WEST SUSSEX COUNTY COUNCIL CONSULTATION

TO:	Arun District Council FAO: Amber Willard
FROM:	WSCC - Highways Authority
DATE:	17 May 2022
LOCATION:	Land to the rear of Clare Court, 67 Barnham Road, Eastergate, PO22 0EP
SUBJECT:	BN/16/22/PL Erection of 4 No dwellings with associated car parking. This application is in CIL Zone 2 and is CIL Liable as new dwellings.
DATE OF SITE VISIT:	n/a
RECOMMENDATION:	More Information
S106 CONTRIBUTION TOTAL:	n/a

PROPOSED SITE PLAN . Scale 1:250 at A3

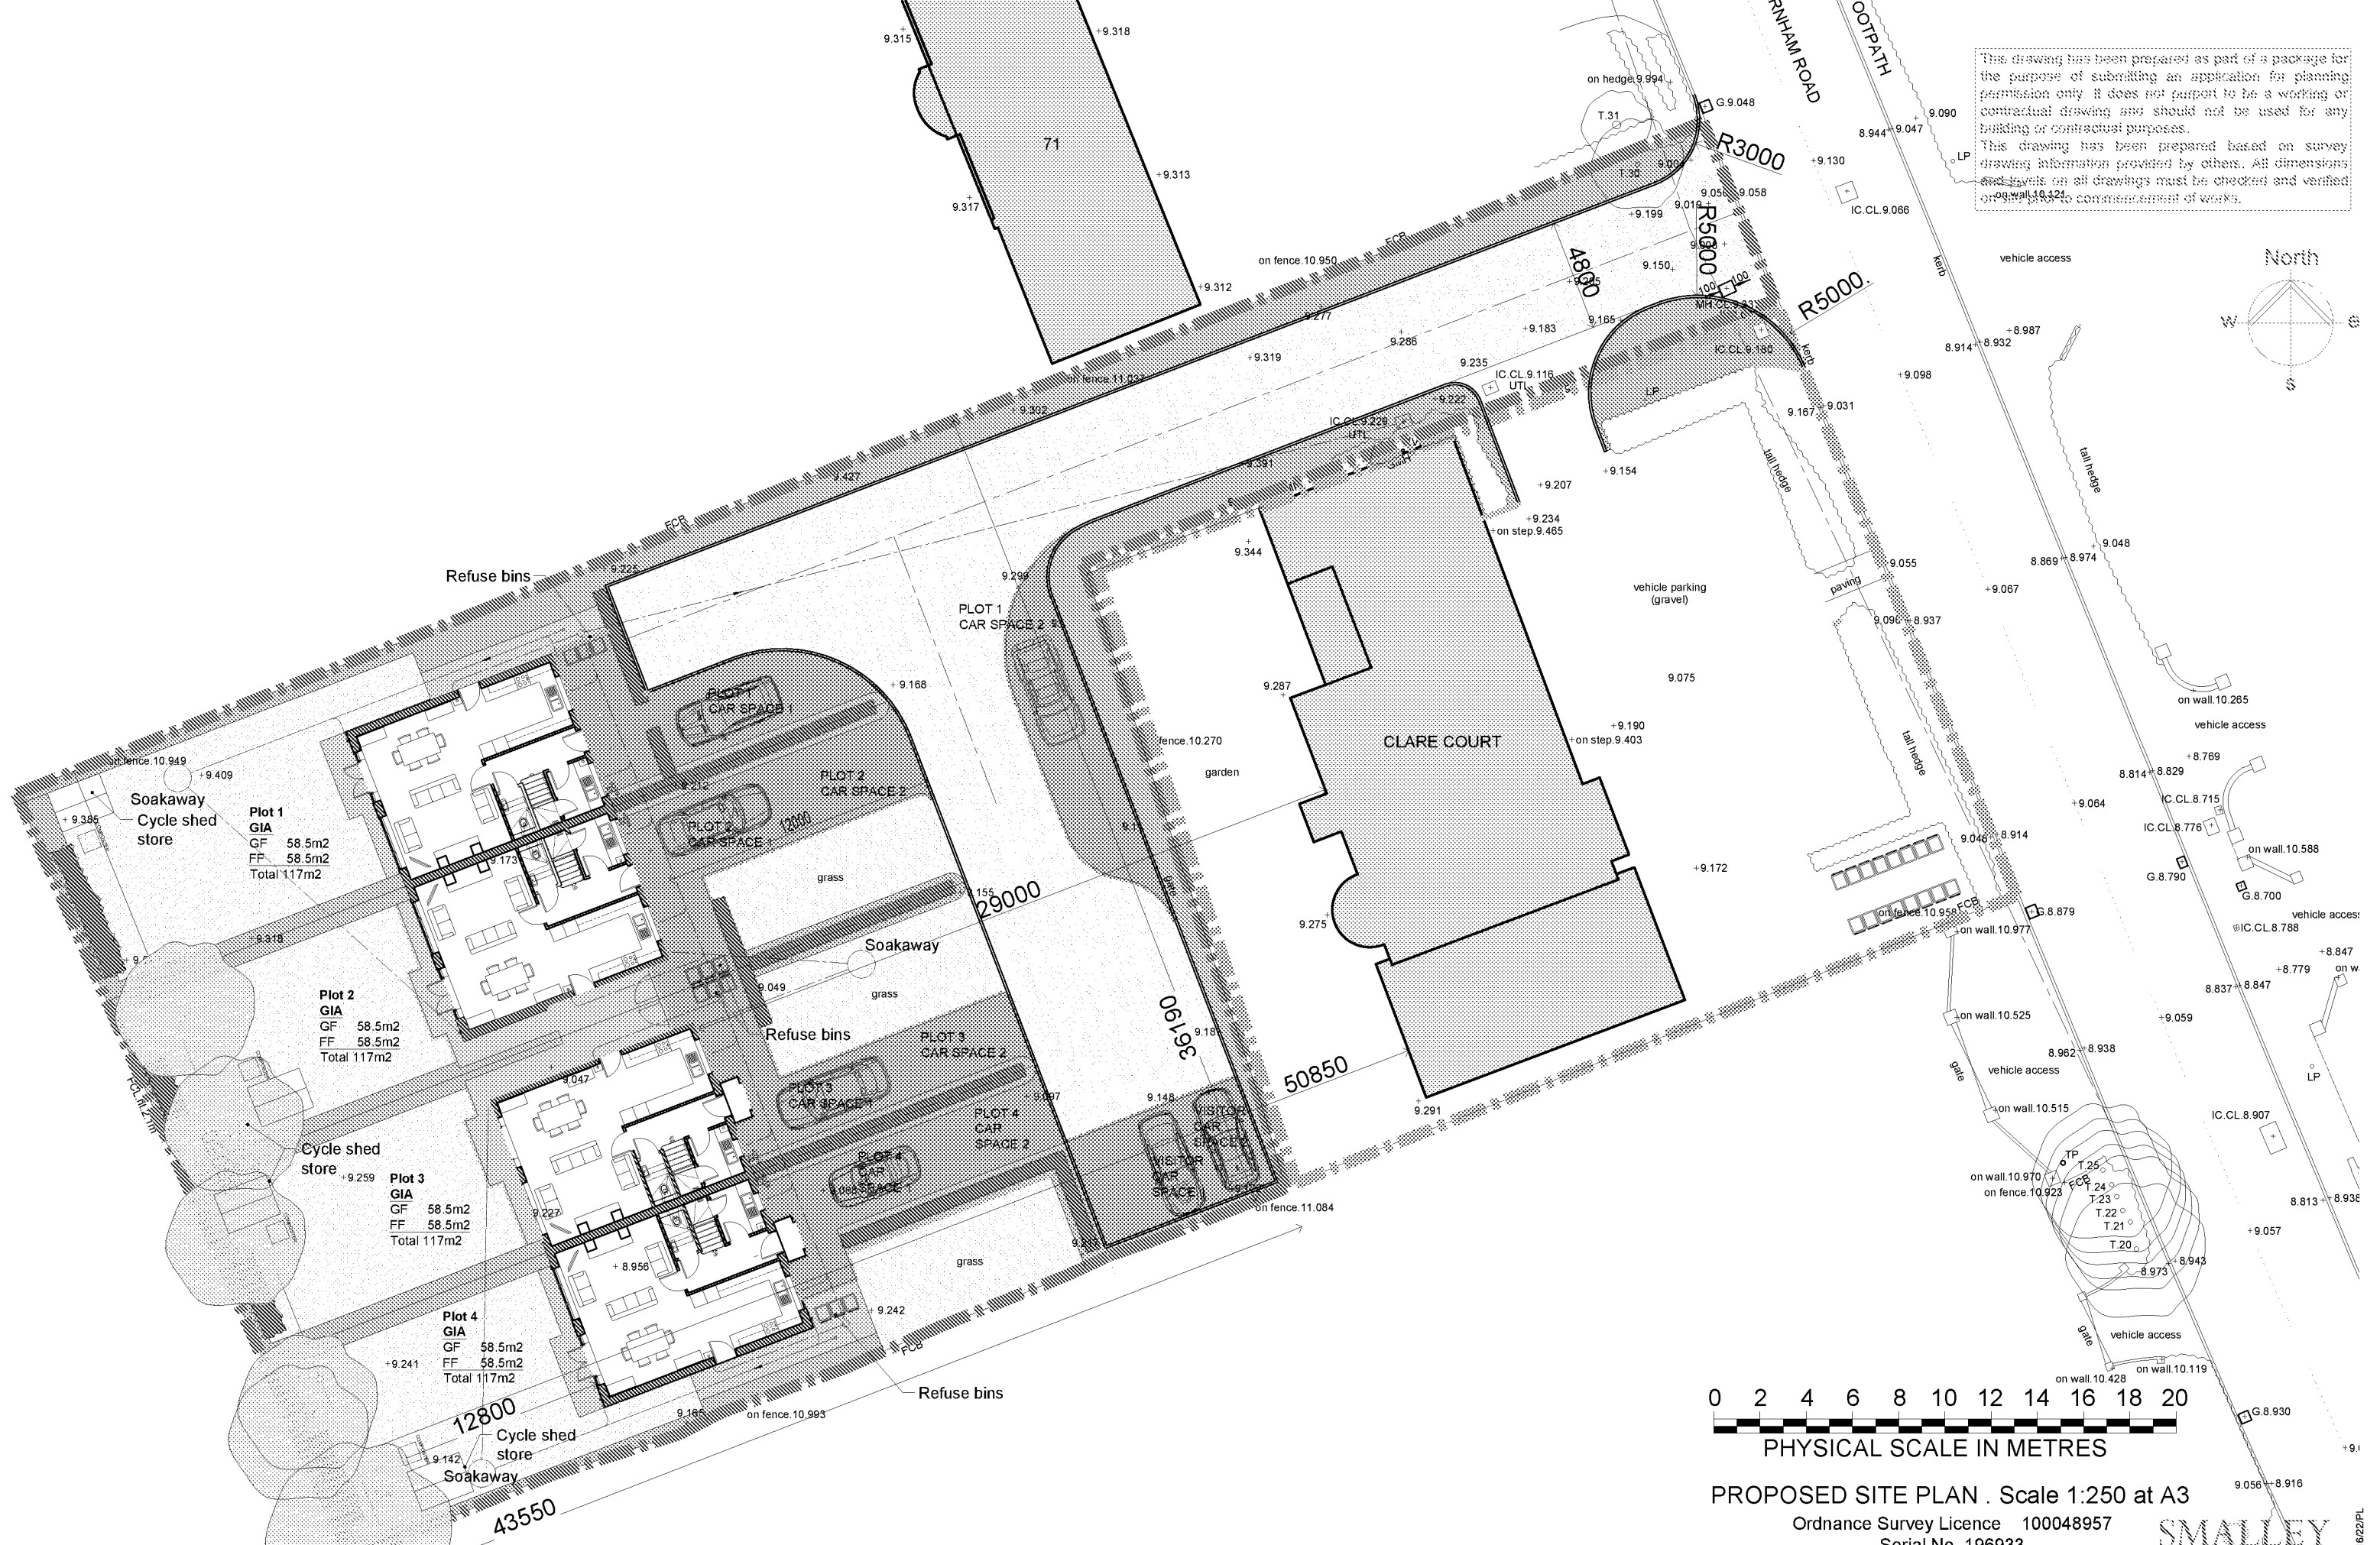
The latest plans detail that the access will be improved with a widened dropped crossing access point. The access way itself will measure circa 4.8 metres in width with the dropped crossing splaying to circa 6.75 metres in width.

Vehicle tracking for a refuse vehicle demonstrates that this geometry vehicle crossover would work.

Within the site tracking has been provided to demonstrate that a refuse vehicle can turn within the confines of the site. This is considered acceptable.

Visibility splays of 2.4 x 43 metres have been demonstrated at the site access point. To the south the splay is contained within the extent of the public highway or under land under control of the applicant. To the north (trailing direction) it has been identified that the splay crosses 3rd party land.

To the north the maximum securable visibility splays have been demonstrated as 2.4 x 9 metres (measured using a 1.0 metre offset). A splay of 2.4 x 18 metres can be achieved if plotted using a 1 metre offset from the centreline.

No dedicated provision has been made to provide a formalised pedestrian link to the existing pedestrian facilities which are located on the opposing side of Barnham Road. There are no formalised pedestrian crossing facilities serving the site as existing. An informal pedestrian crossing point does exist that serves the wider Clare Court, but it is not provided with dropped crossing points or tactile paving.

It seems this application does provide the opportunity to improve upon pedestrian access facilities to the site. This could be by improving the existing informal arrangement by way of dropped crossings on either side of Barnham Road, paired with tactile paving or designing pedestrian access into the vehicle access improvements.

The Local Highways Authority does feel that the application does provide the opportunity to provide wider pedestrian access improvements, namely formalising the existing pedestrian access point with tactile paving and dropped crossings either side of Barnham Road. This would also remove any potential pedestrian / vehicle conflict with a pedestrian choosing to cross by making use of the vehicular access point which does have dropped crossings. Any pedestrian access improvements should be continued into the site, as the current unbound surfacing is not suitable for venerable users such as those in wheelchairs or pushing buggy's / pushchairs.

After review of the site plan this quantum of parking is provided for. Each space is suitably sized and provided the opportunity to turn on site.

Each dwelling should be provided EV Parking provision in accordance with Arun DC Guidance. This has been detailed on the proposed site plans. The specific details of which can be secured via a suitably worded planning condition.
